CCES RESPONSES

RETREAT AT TIMBERRIDGE

Review Comments (43)

Subject: Retreat at TimberRidge Filing No. 1 Final Plat, Review #2 (SF-19-009)

# RETREAT AT TIMBERRIDGE FILING NO. 1

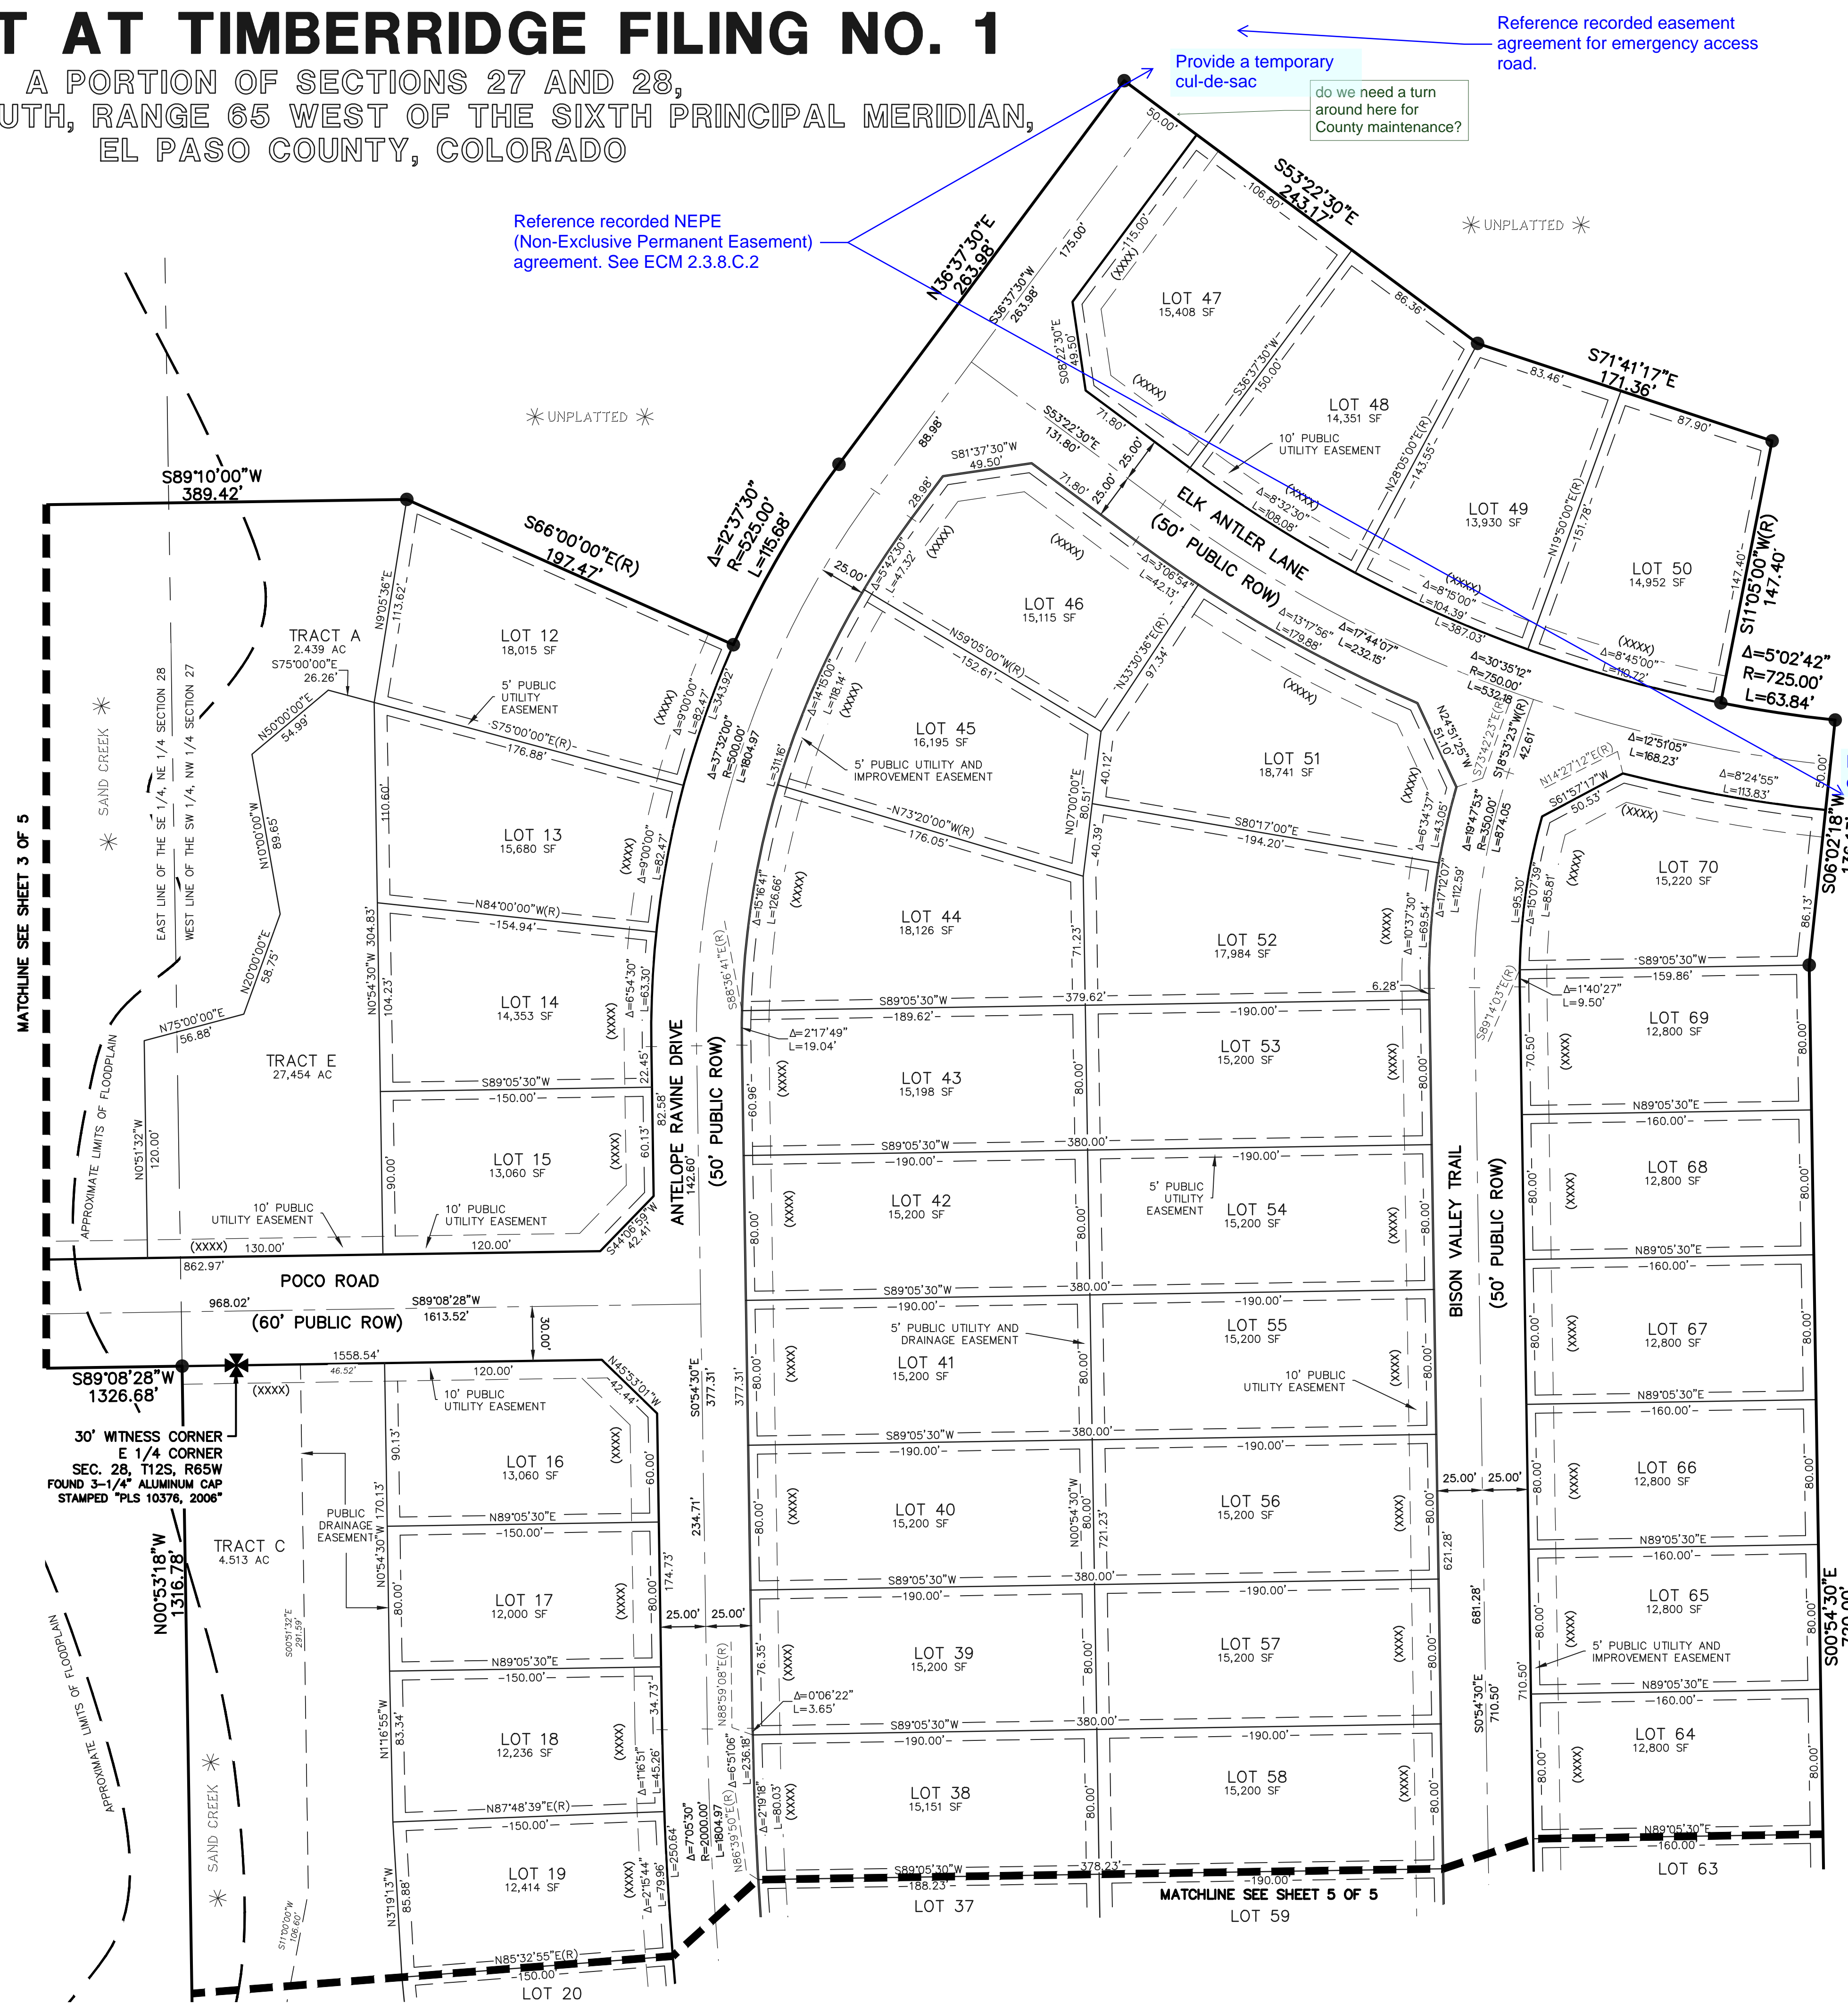
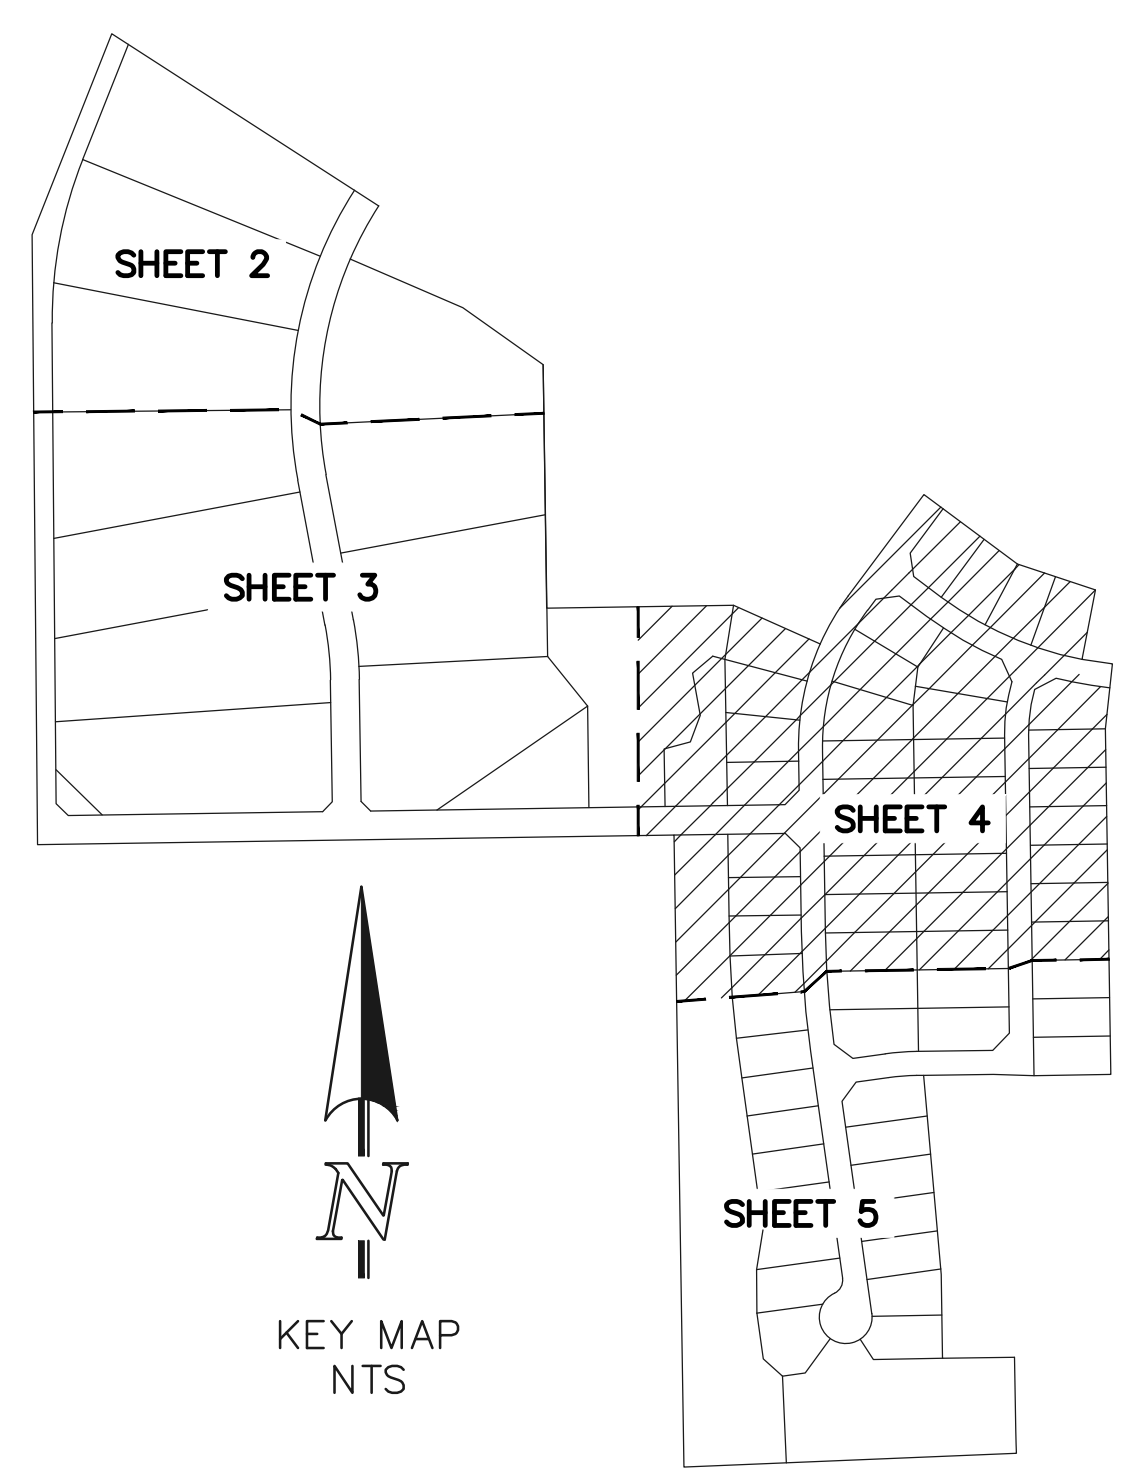
Pikes Peak Regional Building Department	Floodplain has the following comments: 1. Base flood elevations are not shown on this plat as required by Regional Building Code section RBC313.18.5. Contact Floodplain Administrator Keith Curtis (keith@pprbd.org, 719-327-2898) to discuss compliance with floodplain code. Noted. BFE's now shown on plat Brent Johnson Enumerations Plans Examiner Pikes Peak Regional Building Department O: 719-327-2888 E: brent@pprbd.org W: pprbd.org	10/31/2019 3:22:35 PM
View	Parks Advisory Board	El Paso County Community Services / Parks Final Comments, Review #2 - Please See Attached Documents (PAB Endorsed 05/08/2019)	10/31/2019 9:43:50 AM
View	EPC Parks Department	El Paso County Community Services / Parks Final Comments, Review #2 - Please See Attached Documents (PAB Endorsed 05/08/2019)	10/31/2019 9:41:58 AM
	PCD Project Manager	Please upload the revised document stand alone (not attached to redlines); so the line item in EDARP is the official document not the revisions...You can upload all your responses as an option line item if you like. Noted	10/30/2019 11:59:36 AM

View	EPC Environmental Services		10/21/2019 10:12:07 AM
	911 Authority - El Paso/Teller County	No additional comments from E911 Glenn West	10/15/2019 7:57:57 AM
	RBD Floodplain	FEMA approved base flood elevation data and 100-year floodplain boundaries shall be provided and shown on plat;	10/14/2019 8:46:53 AM
